6 March 2019

Section 4.55(1) modification to correct minor administrative errors in relation to SSD 9036 – Concord Repatriation General Hospital redevelopment (Concept and Stage 1)

On 28 February 2019, the Minister's delegate approved the above project which included Concept approval and Stage 1 development approval for the redevelopment of Concord Repatriation General Hospital. It has come to our attention that there were a number of minor administrative errors in relation to document references at Schedule 3 – Conditions of Approval for Stage 1 – Part A Administrative Conditions, Condition A2.

DRAWN: GA/MM/MR/EF	DRAWING CHECK: WB
DESIGNED: AC/DG	DESIGN REVIEW: CY
REVIEWED:	DATE:
APPROVED:	DATE:
SCALE: 1 : 400	
PROJECT No: IA064700	DRAWING No: NEWB-AR-DRG-0050
REV	10

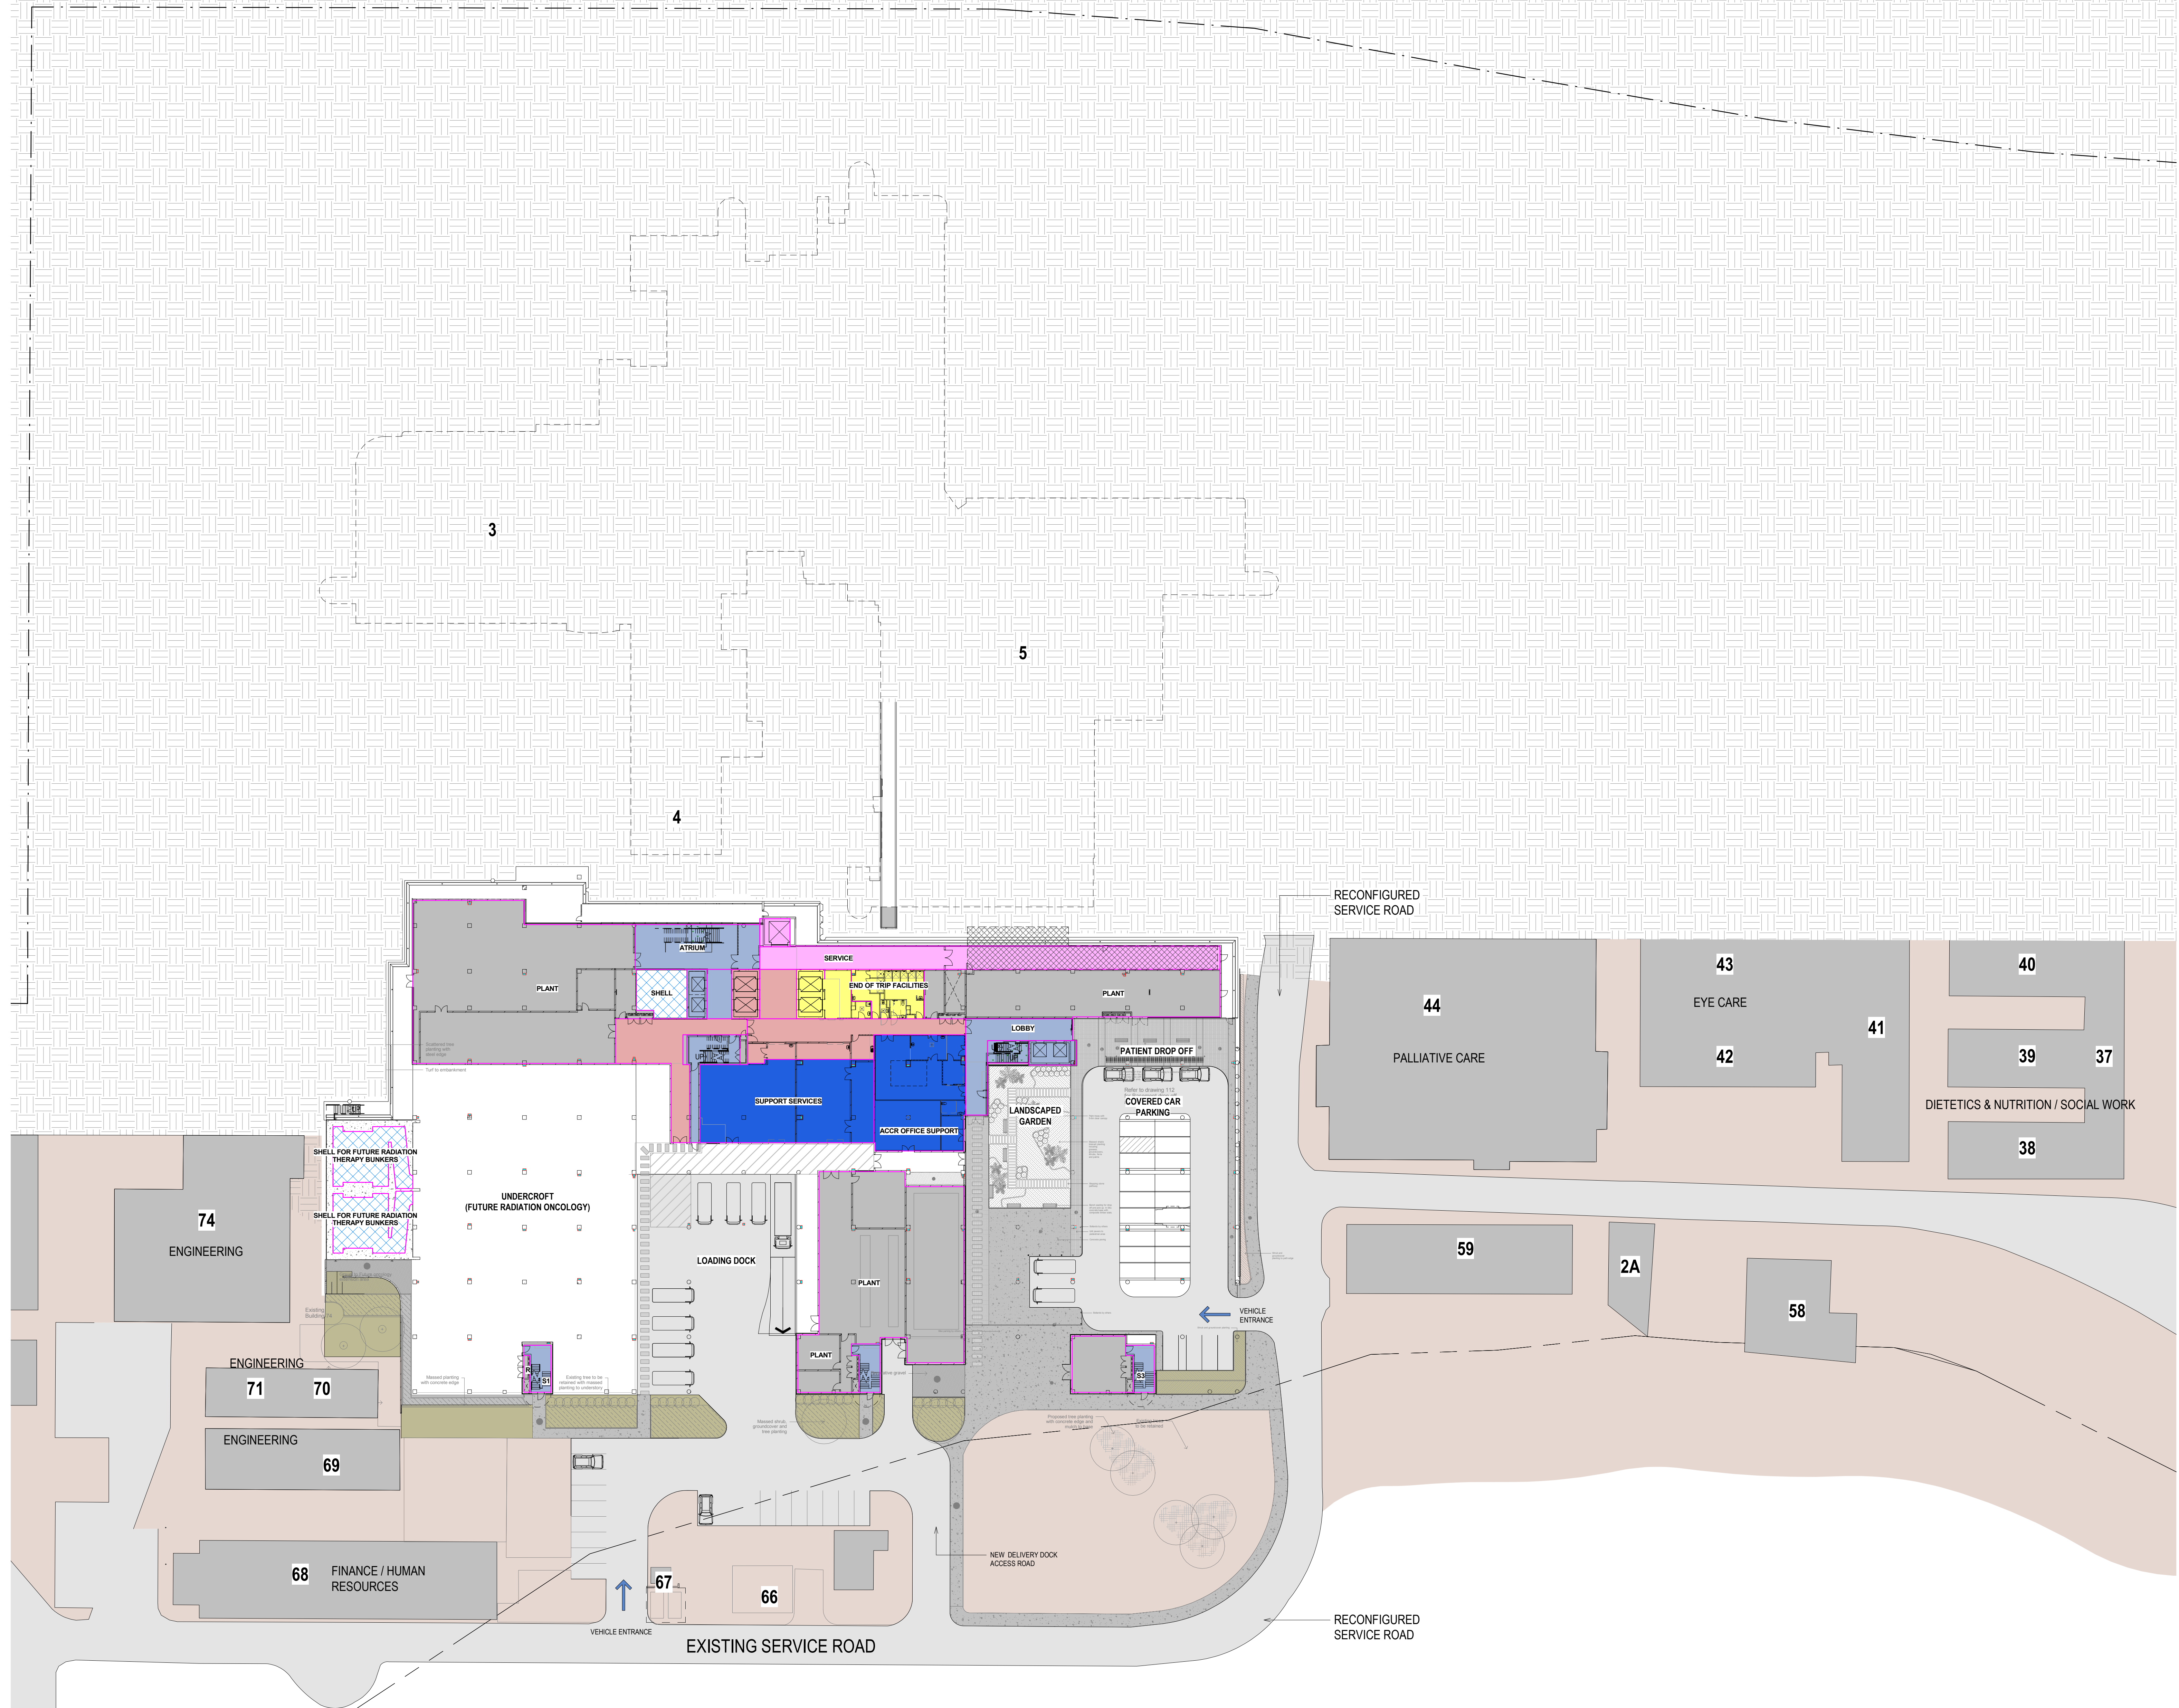
Architectural Drawings prepared by Jacobs				
Dwg No.	Rev	Name of Plan	Date	Comment
IA064700-NEWB-AR-DRG-00	5	Cover Sheet	27/07/18	Insert drawing
IA064700-NEWB-AR-DRG-00050 00151	10	Overall Plan – Basement	22/06/18	Amend drawing number
IA064700-NEWB-AR-DRG-7900	4	Shadow Diagram Summer	22/06/18	Delete reference
IA064700-NEWB-AR-DRG-7904	4	Shadow Diagram Winter	22/06/18	Delete reference
